**EPC STORMWATER REVIEW COMMENTS
 IN ORANGE BOXES WITH BLACK TEXT**

EL PASO COUNTY STORMWATER MANAGEMENT PLAN CHECKLIST

EPC Project Number: **SF2427**

GRADING & EROSION CONTROL PLAN
COVER

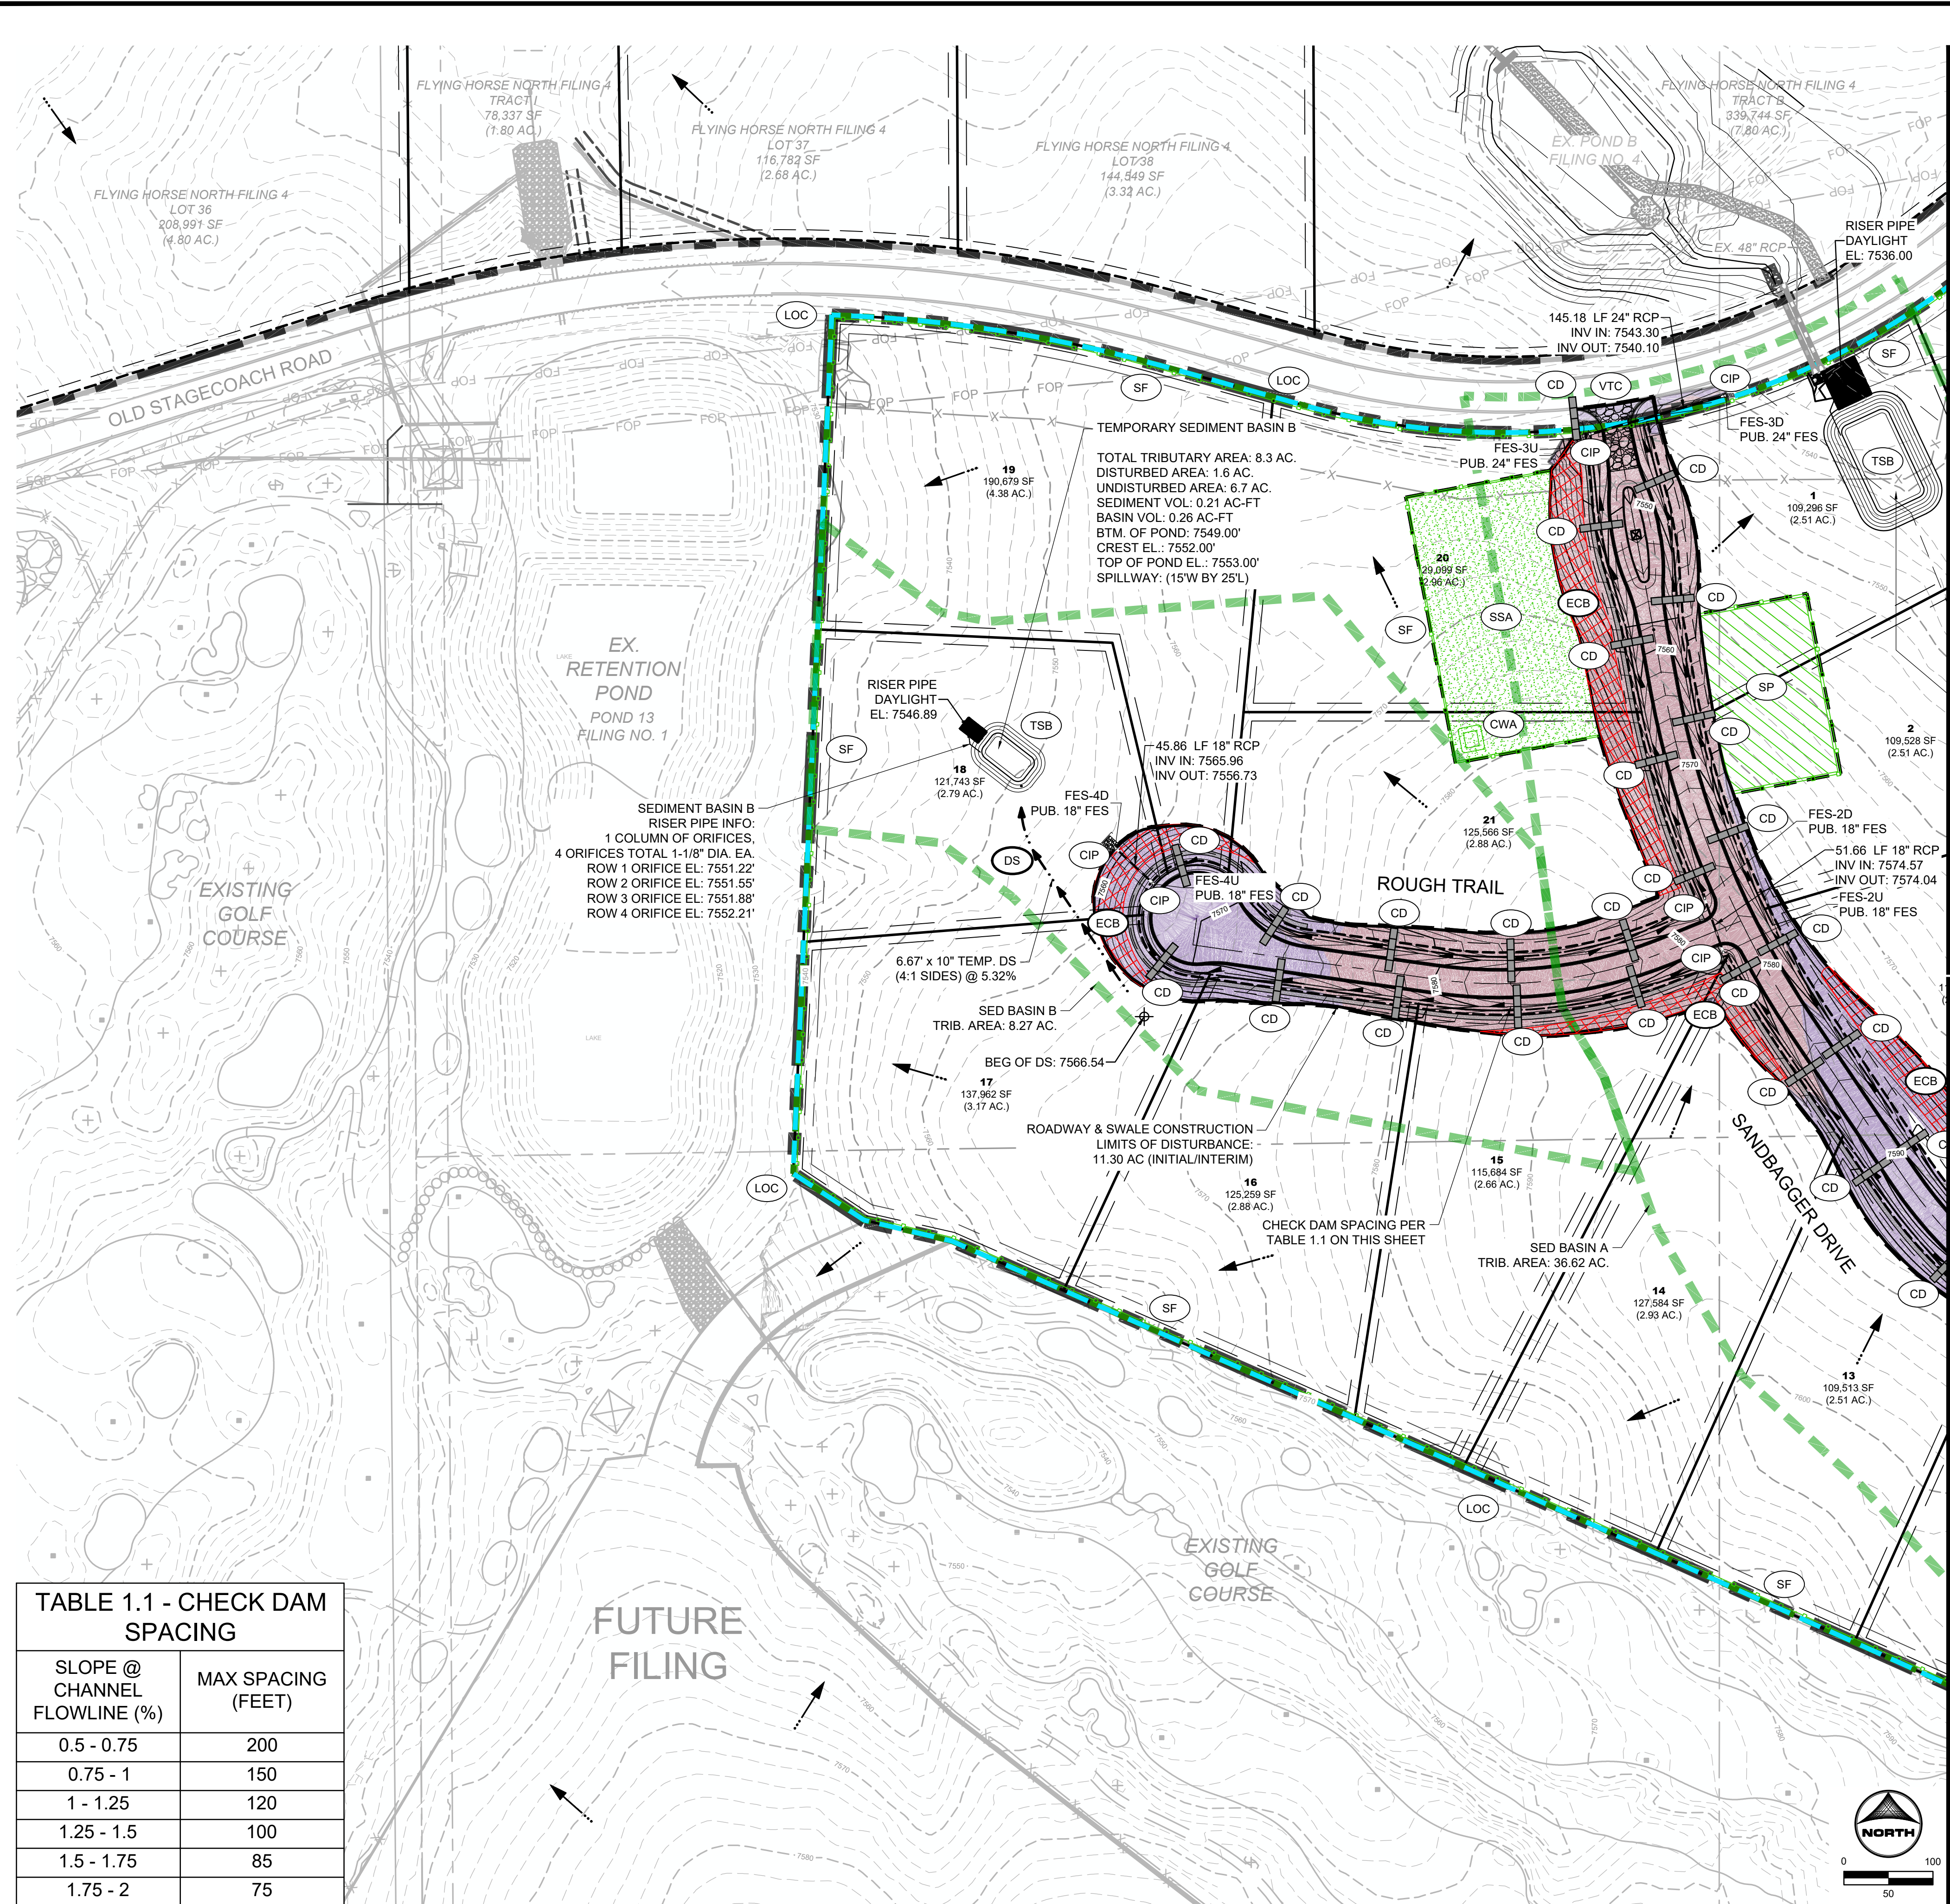
Applicant	EPC
1. STORMWATER MANAGEMENT PLAN (in the "Applicant" column specify the page number for each item)		PAGE NO.	
1	Applicant (owner/designated operator), SWMP Preparer, Qualified Stormwater Manager, and Contractor Information. (On cover/title sheet)		N
2	Table of Contents		Y
3	Site description and location to include: vicinity map with nearest street/crossroads description		Y
4	Narrative description of construction activities proposed (e.g., may include clearing and grubbing, temporary stabilization, road grading, utility / storm installation, final grading, final stabilization, and removal of temporary control measures)		Y
5	Phasing plan – may require separate drawings indicating initial, interim, and final site phases for larger projects. Provide "living maps" that can be revised in the field as conditions dictate		Y
6	Proposed sequence for major activities: Provide a construction schedule of anticipated starting and completion dates for each stage of land-disturbing activity depicting conservation measures anticipated, including the expected date on which the final stabilization will be completed		Y
